## Application for a Non-Material Amendment Following a Grant of Planning Permission

Erection of two storey apartment building containing 10no. units, including associated landscaping, vehicle access with parking, following demolition of existing bungalow

22/02349/FULM

**Typical Proposed Plans**

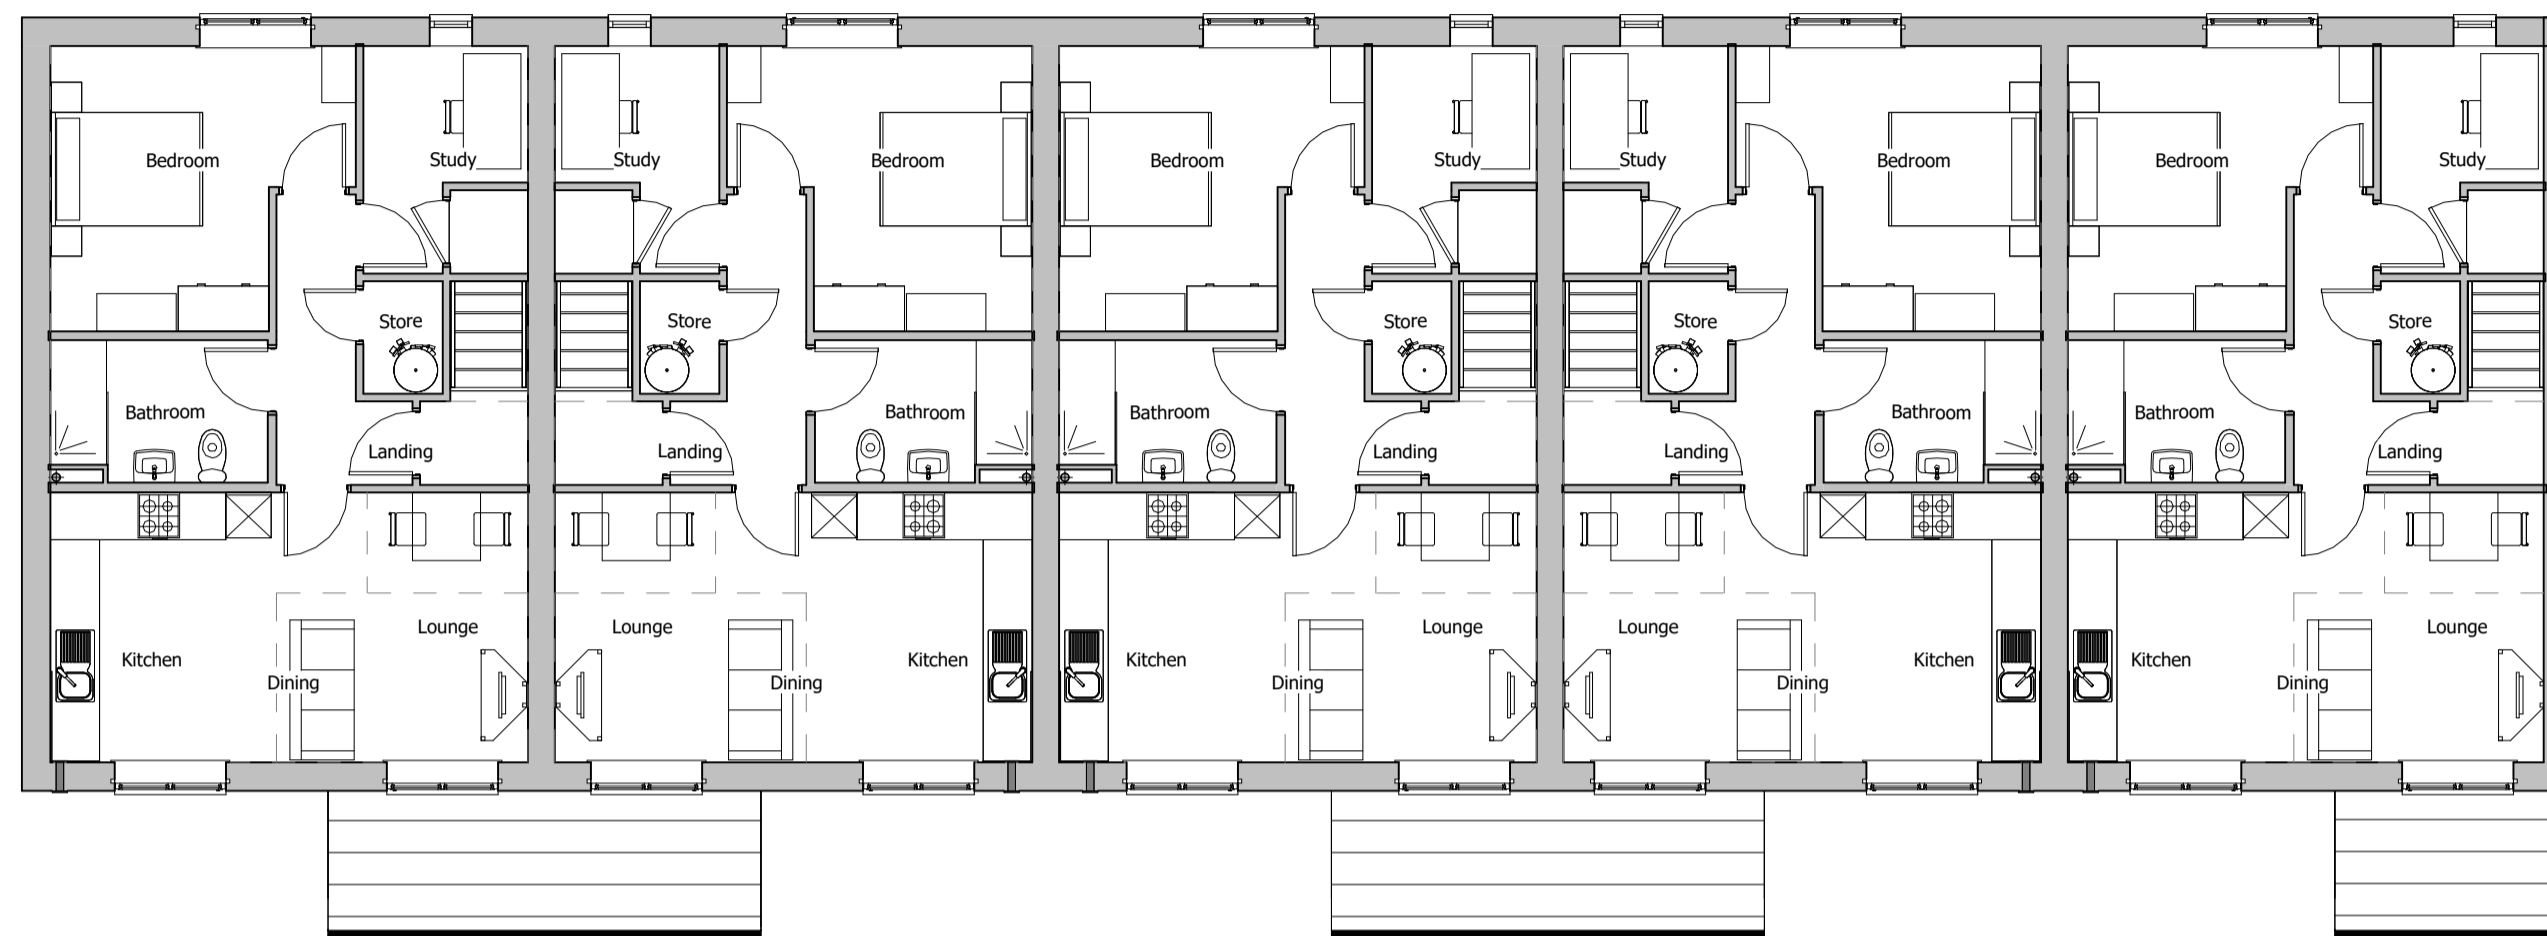
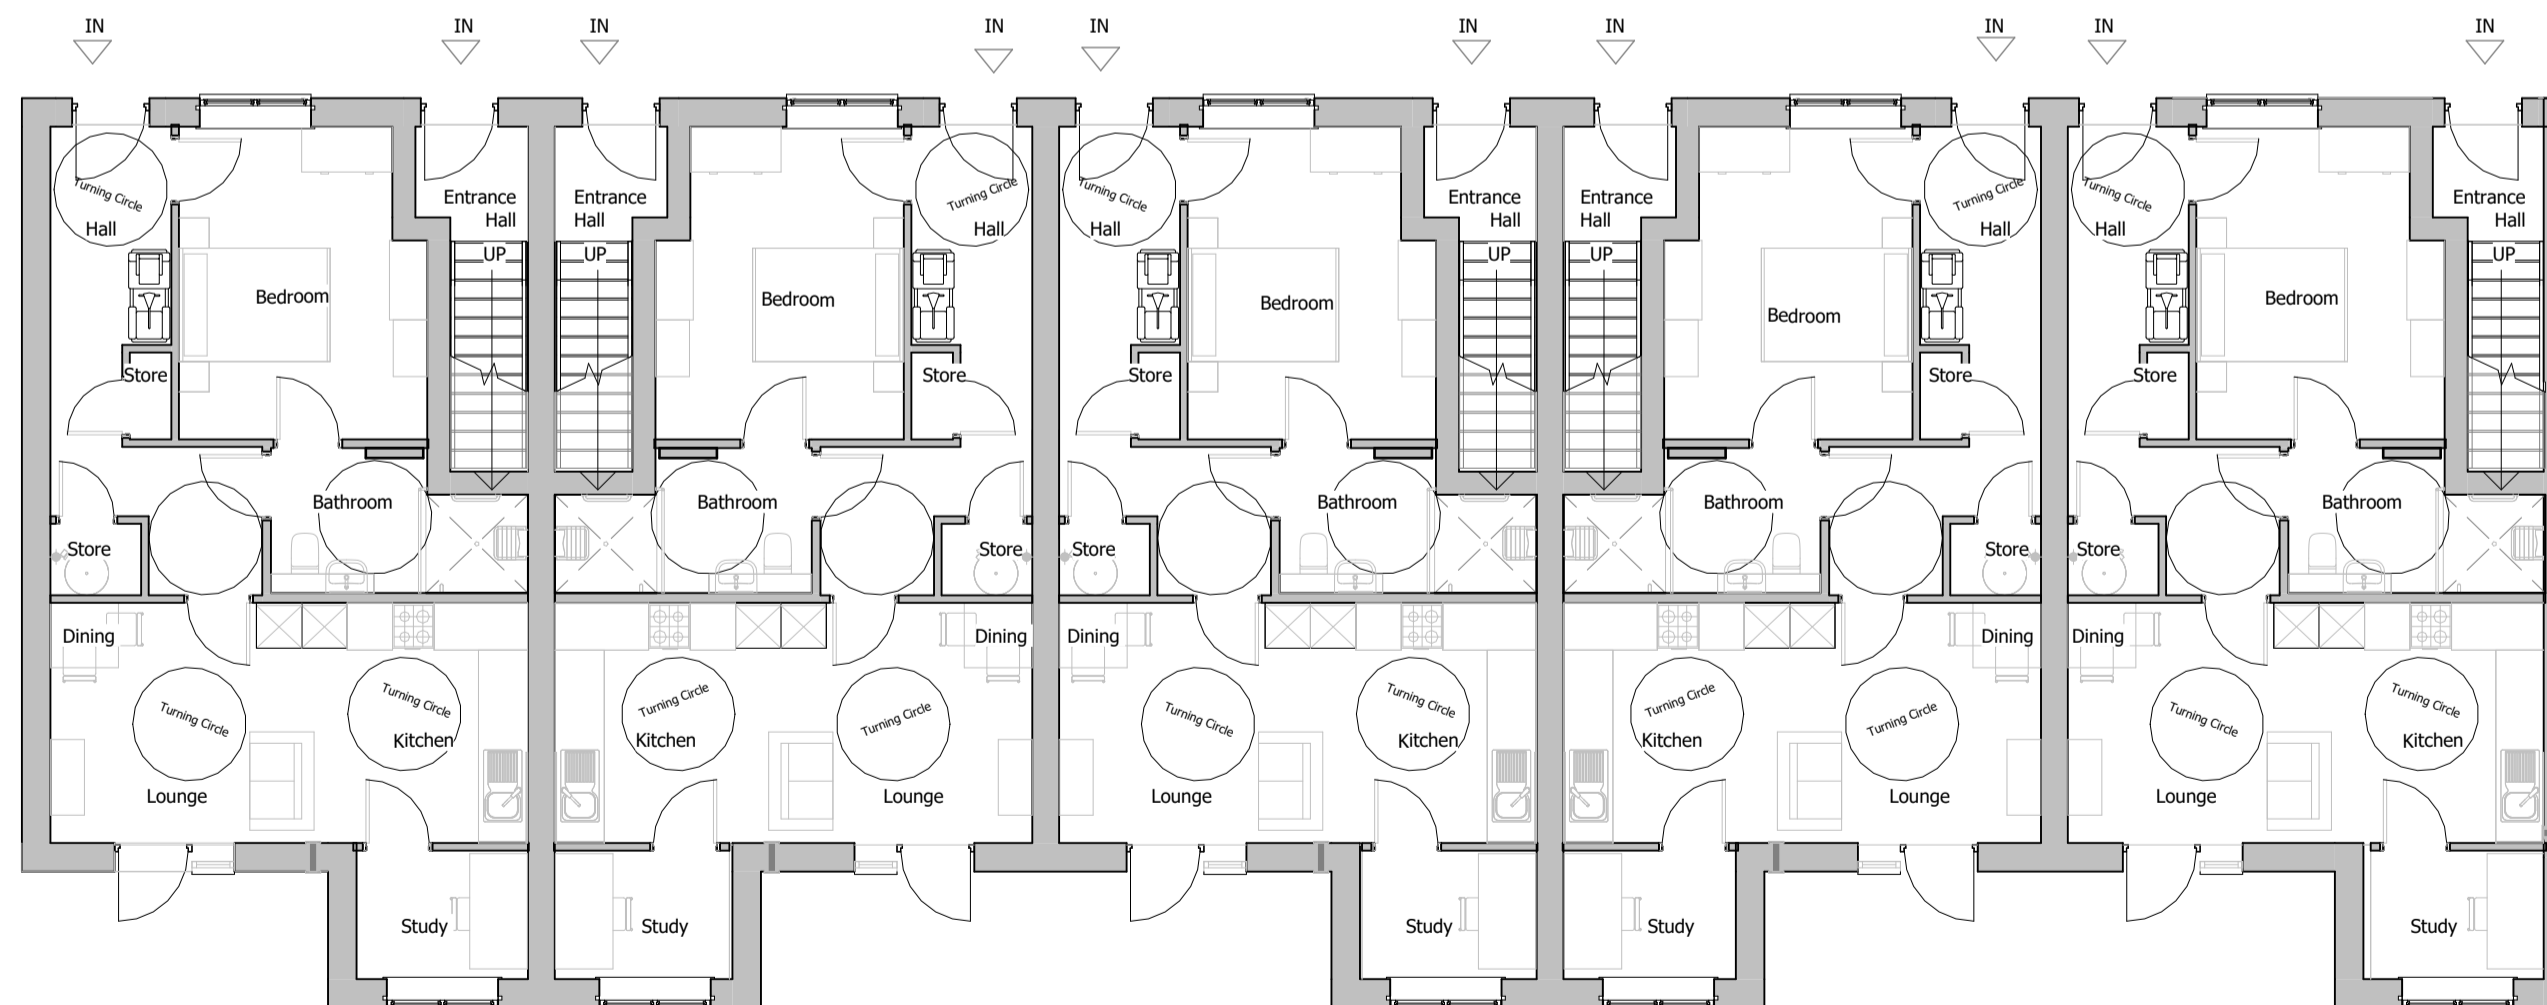
1. Removal of reference to ASHP and the ASHP surround on Proposed Site plan
2. change on door fenestration to rear elevation GF apartment.
